Rezoning Transportation Analysis

Petition Number: 2021-154

Revision Log:

Date	Description
12-28-2021	First Review (KP)
01-27-2022	Second Review (KP)
03-02-2022	Third Review (KP)

Project and sheet information table. Includes Project Name (Price Lane Townhomes PHII), Petition Number (2021-XXX), Sheet Number (RZ-01), and a revision table with columns for REV., DATE, and DESCRIPTION.

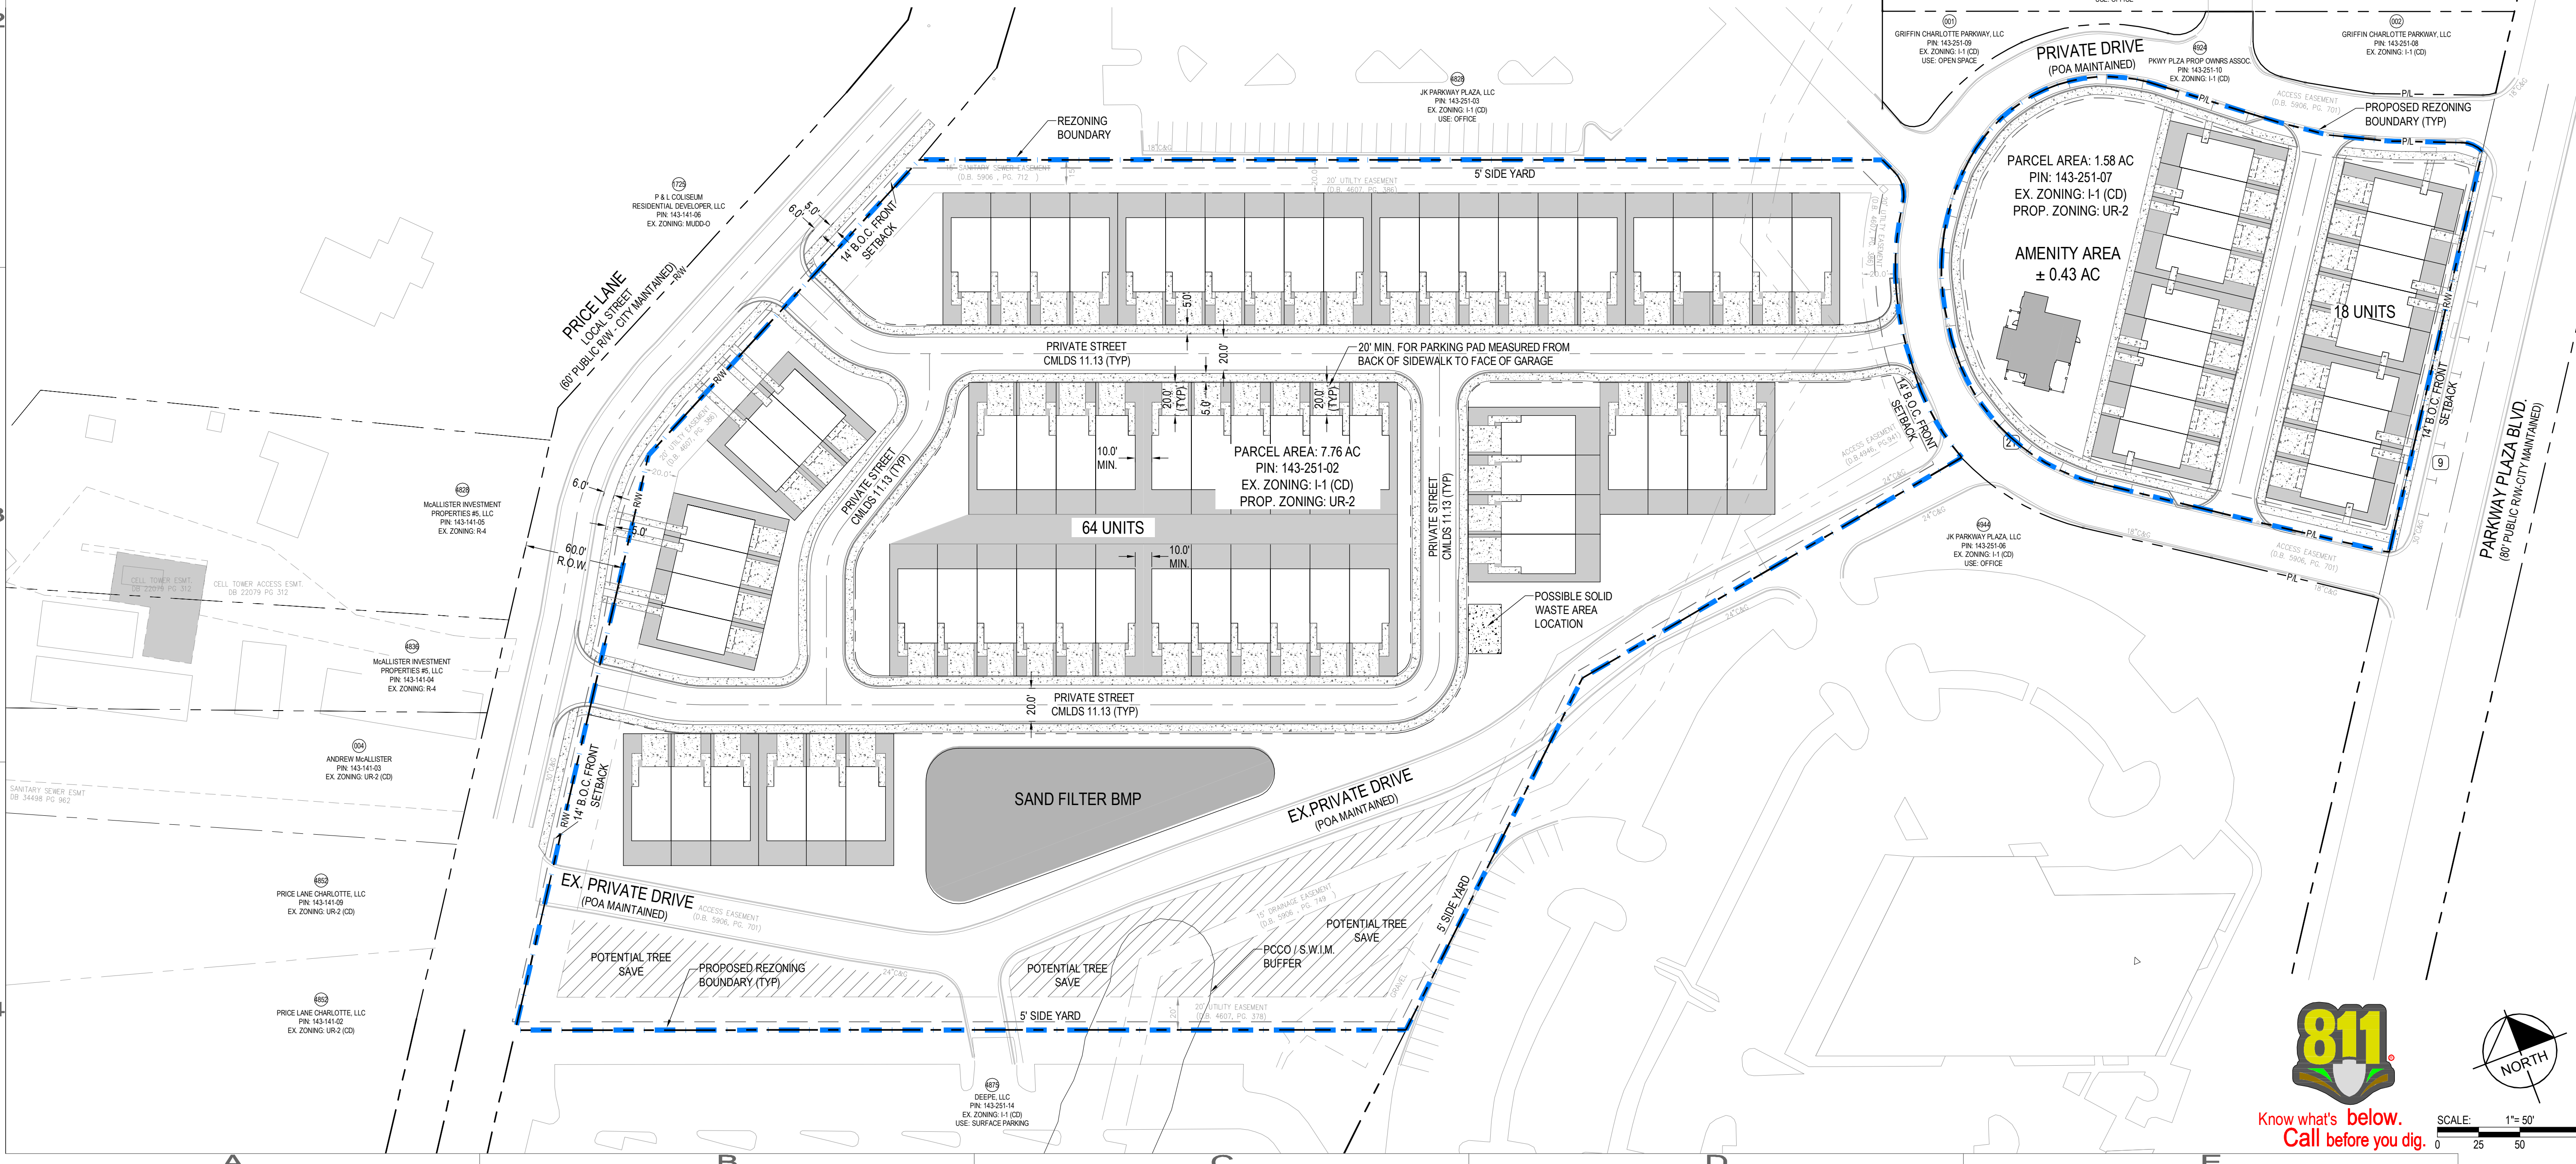
5. ~~Revise the site plan by showing the missing 8 townhomes.~~

Please show the 8 units on the site plan

TECHNICAL DATA /  
SCHEMATIC SITE

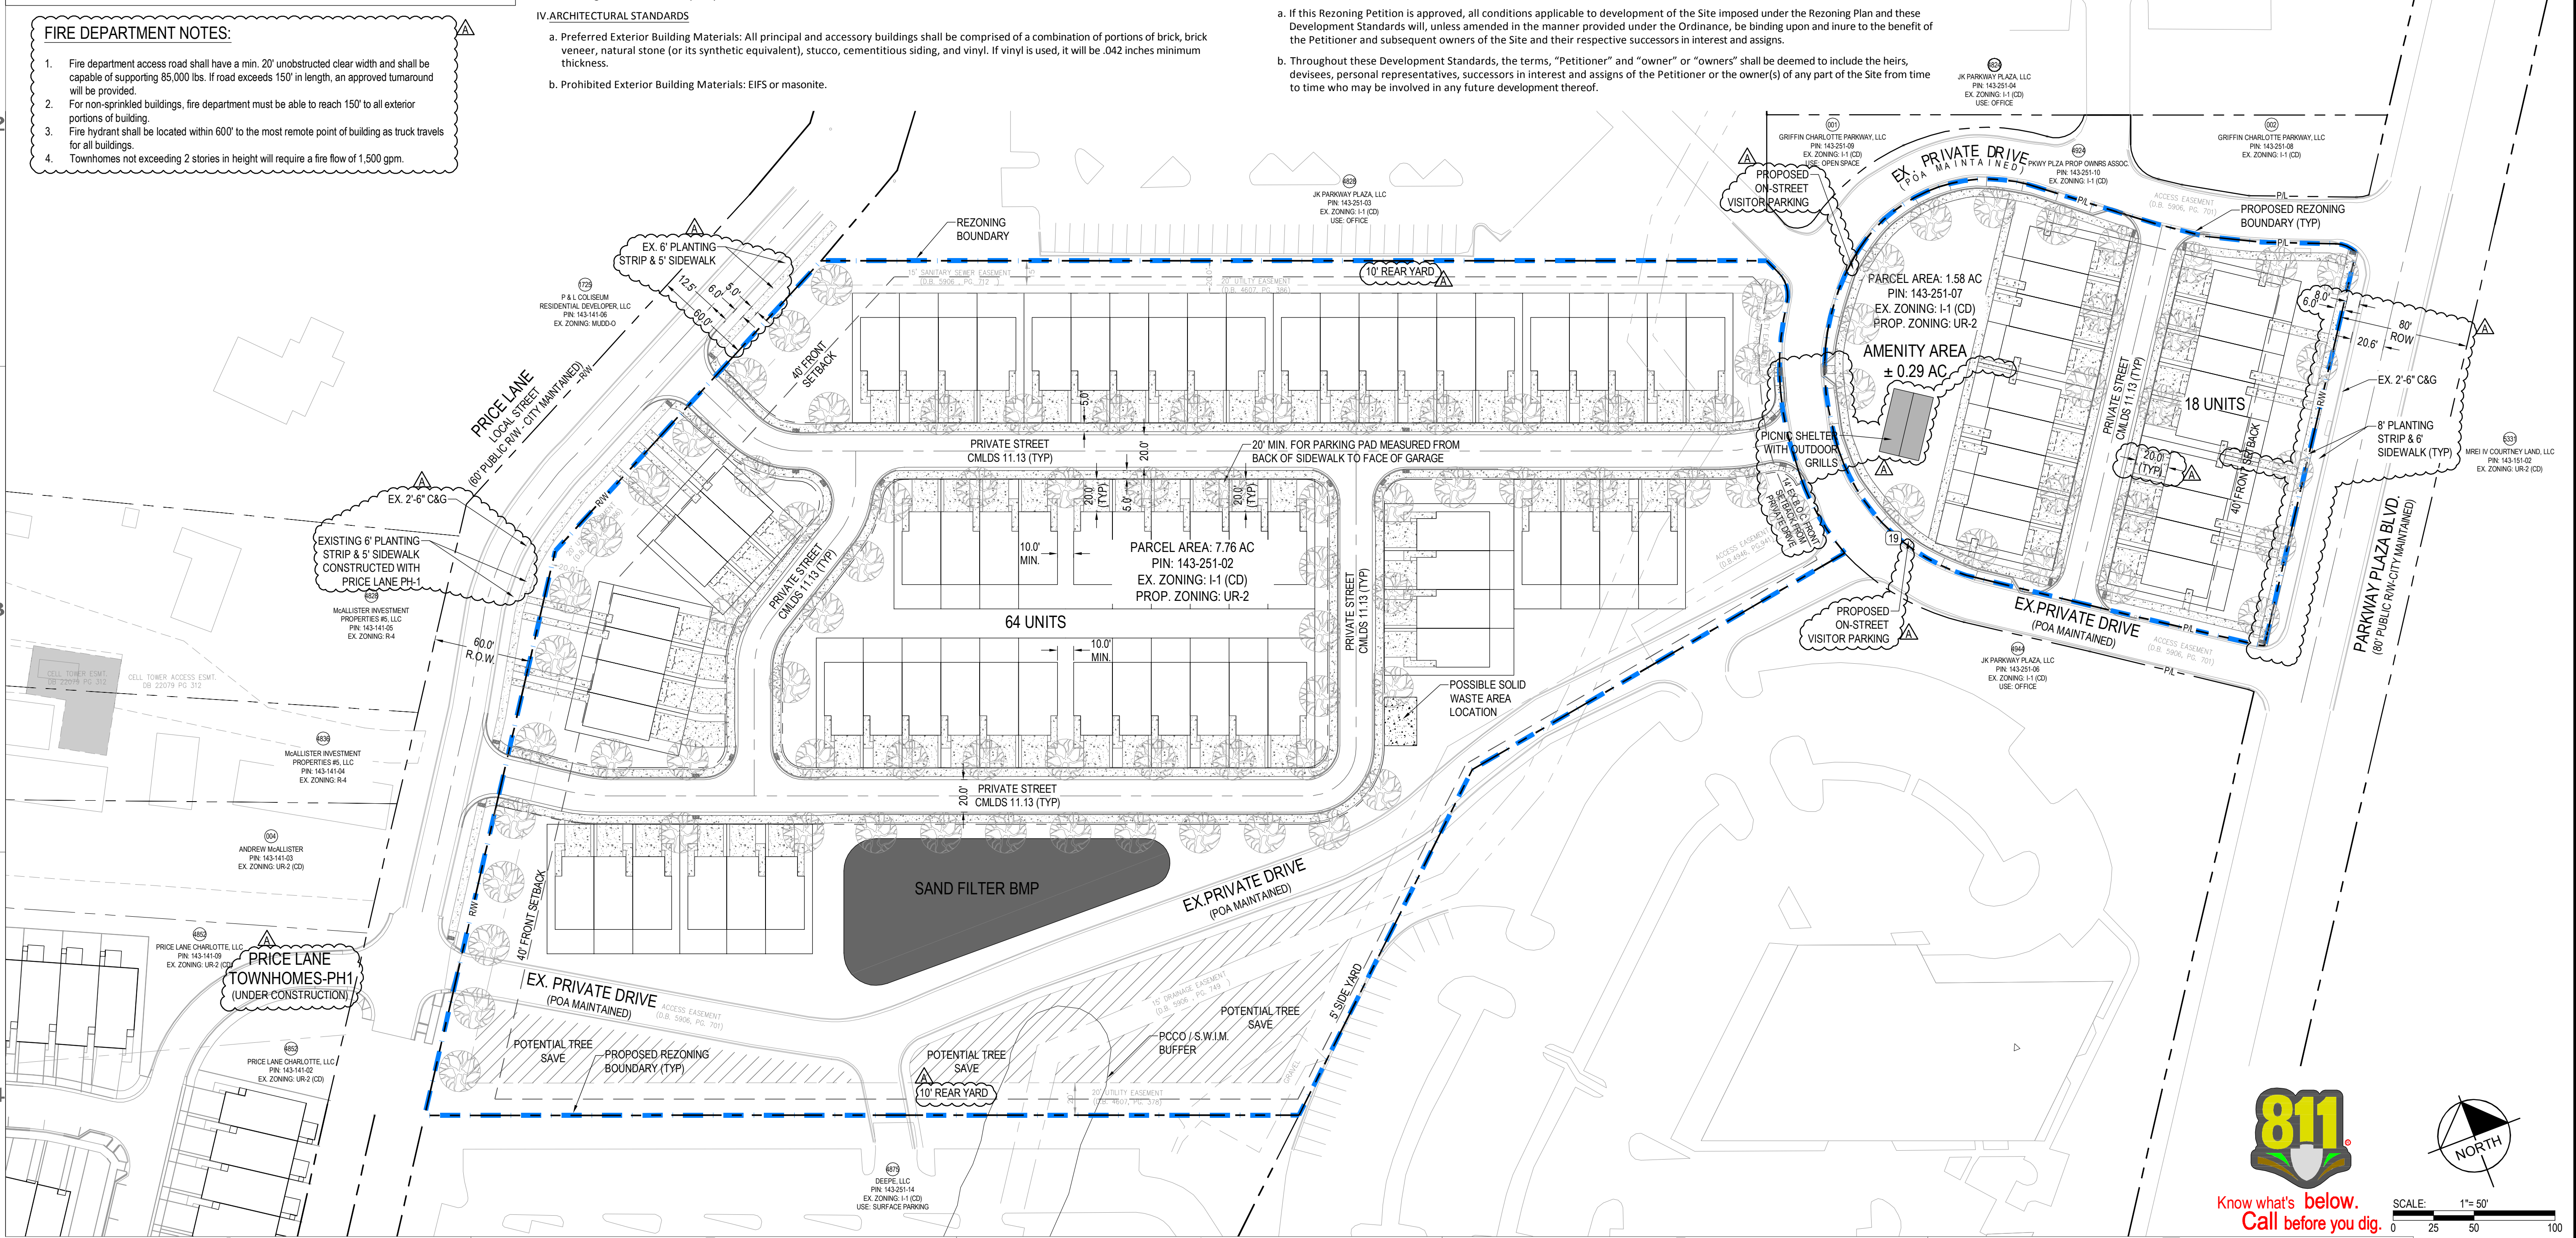
Comment rescinded after coordination with the petitioner: Update to Comment from 01-17-2022 Site Plan: Revise the site plan and conditional note III.b by removing the proposed southern driveway on Price Lane.

b. The maximum number of access points on Price Lane shall be two (2).
